Subject: RE: Planning Consultation on: BE/43/08/A JC

OBJECTION

TITLE	DATE
North Bersted Flag Location Plan	Mar 08
DRAWN	DK

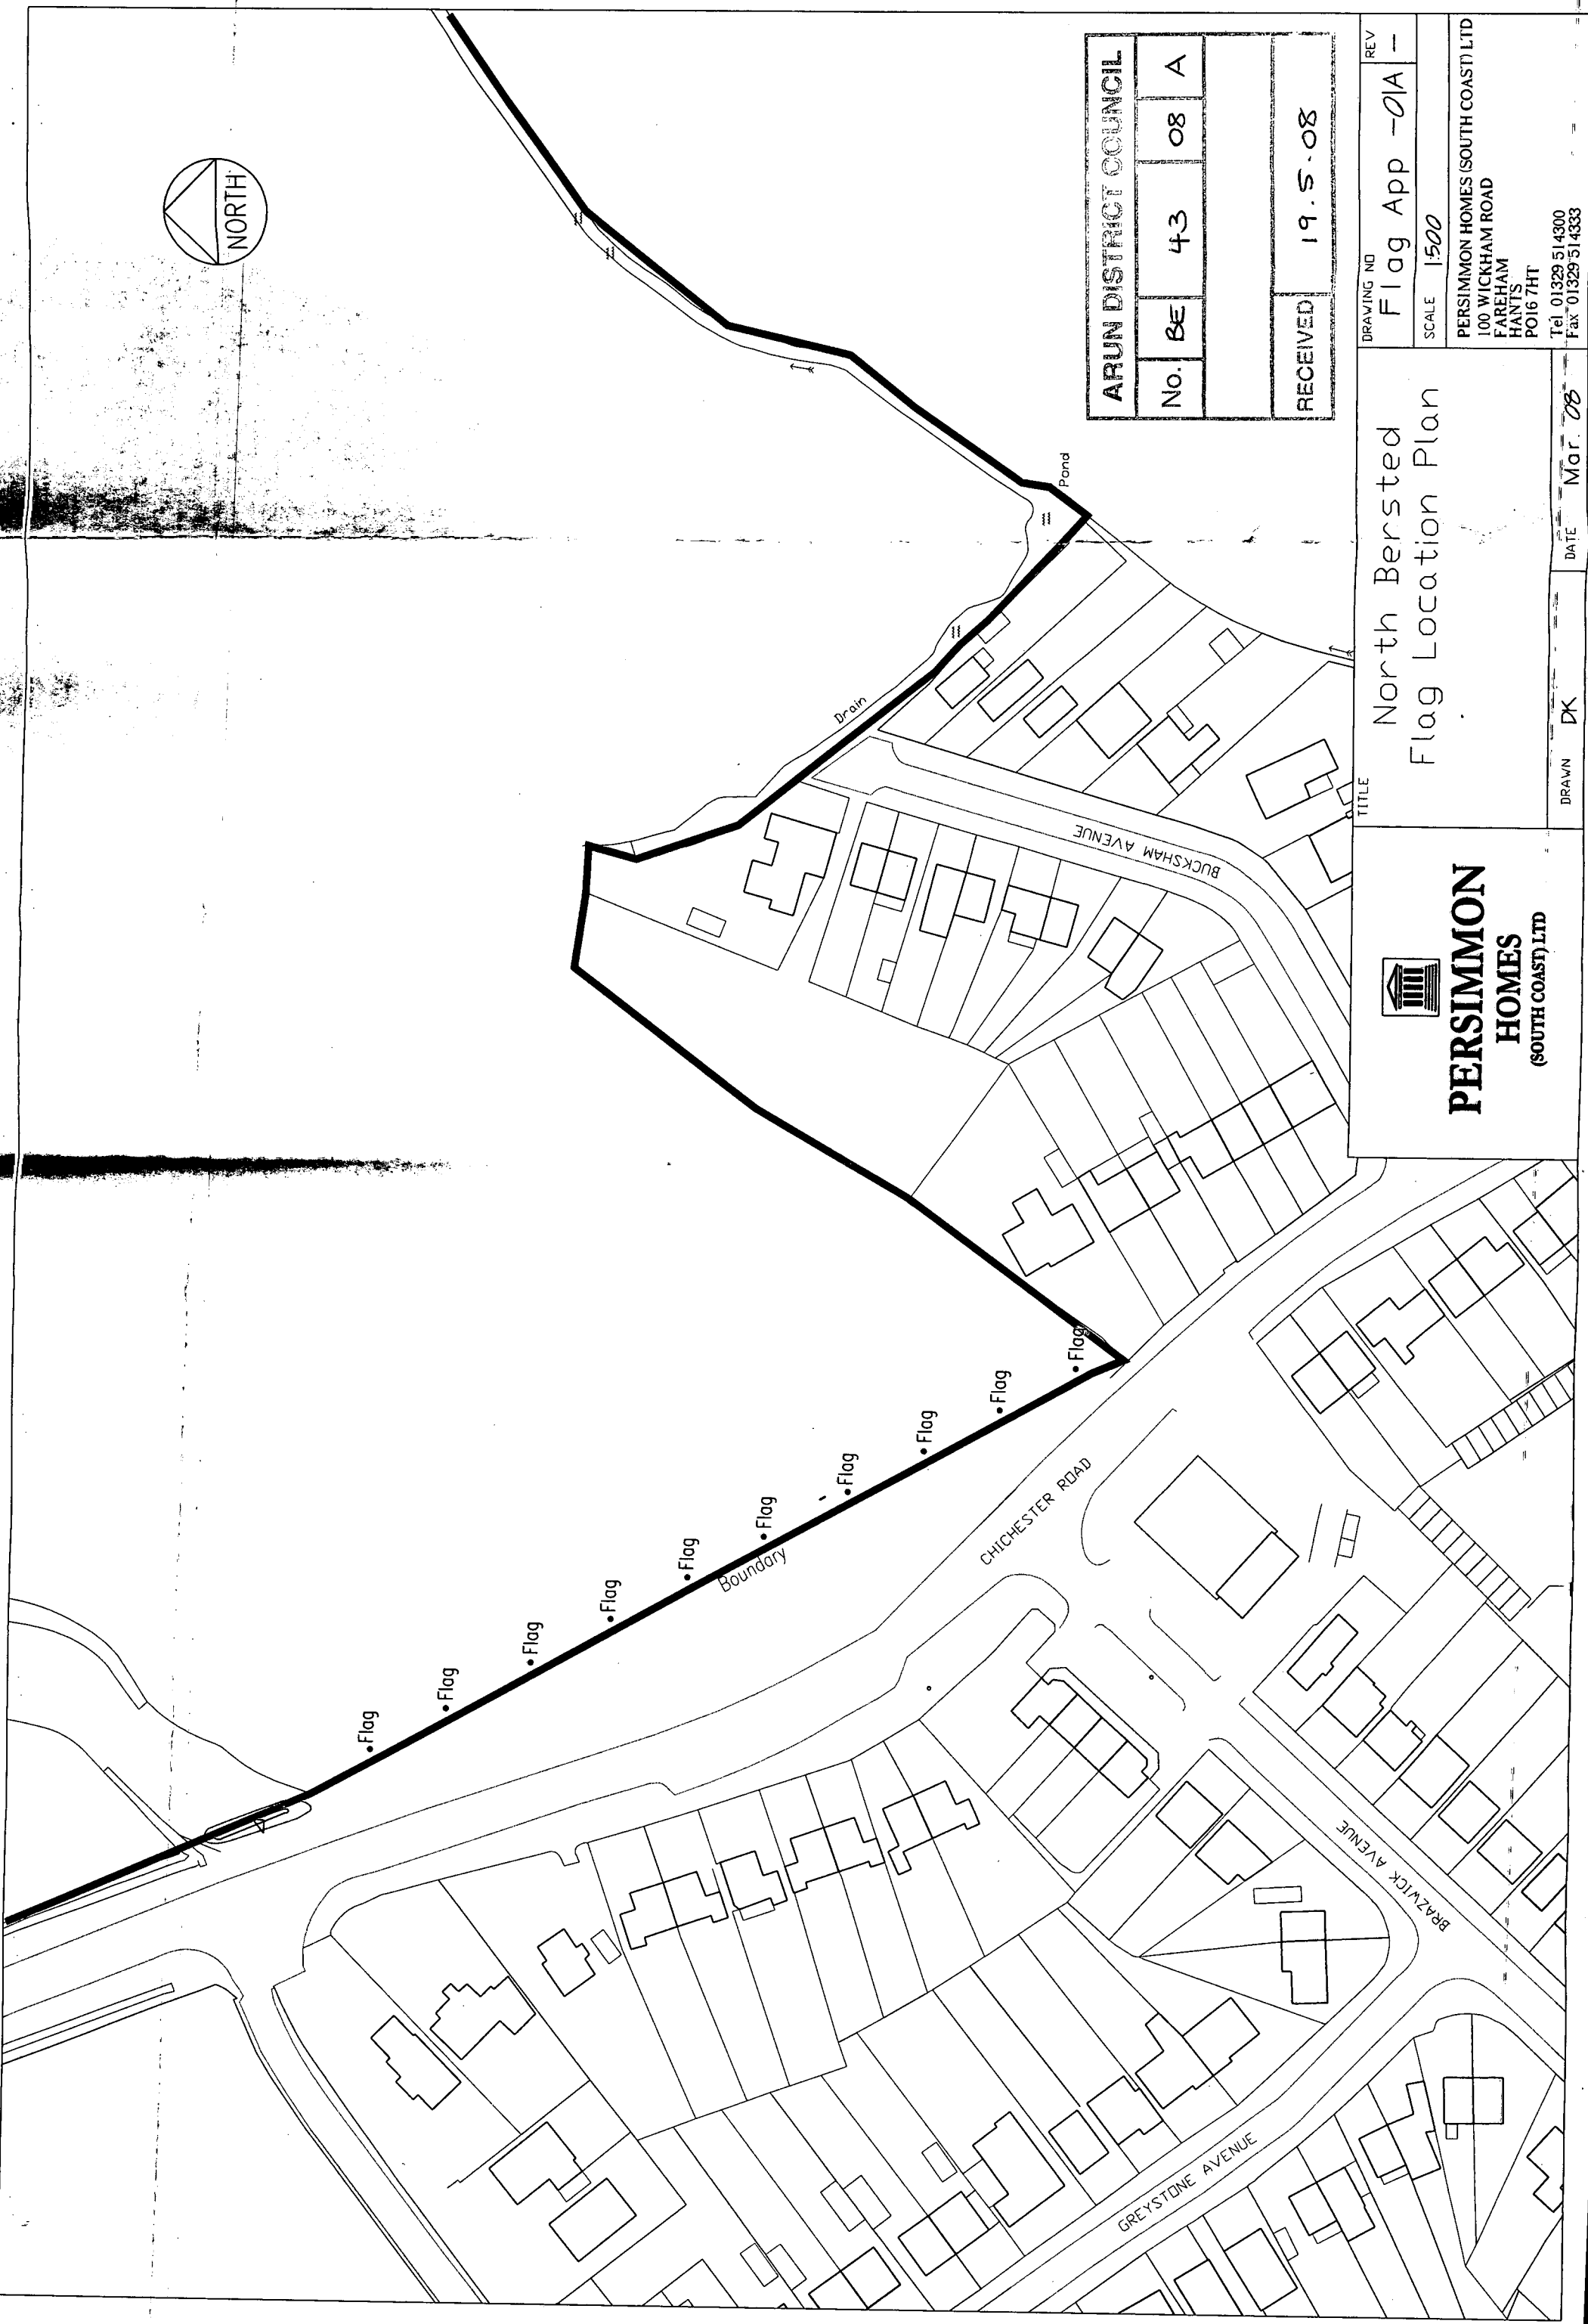
The flagpoles will be out of character in a semi-rural setting and will obstruct the remaining open views of the countryside. The poles will be un-neighbourly to the properties on the opposite side of the road overlooking the site. The flag poles will be a distraction to drivers on this very busy road.
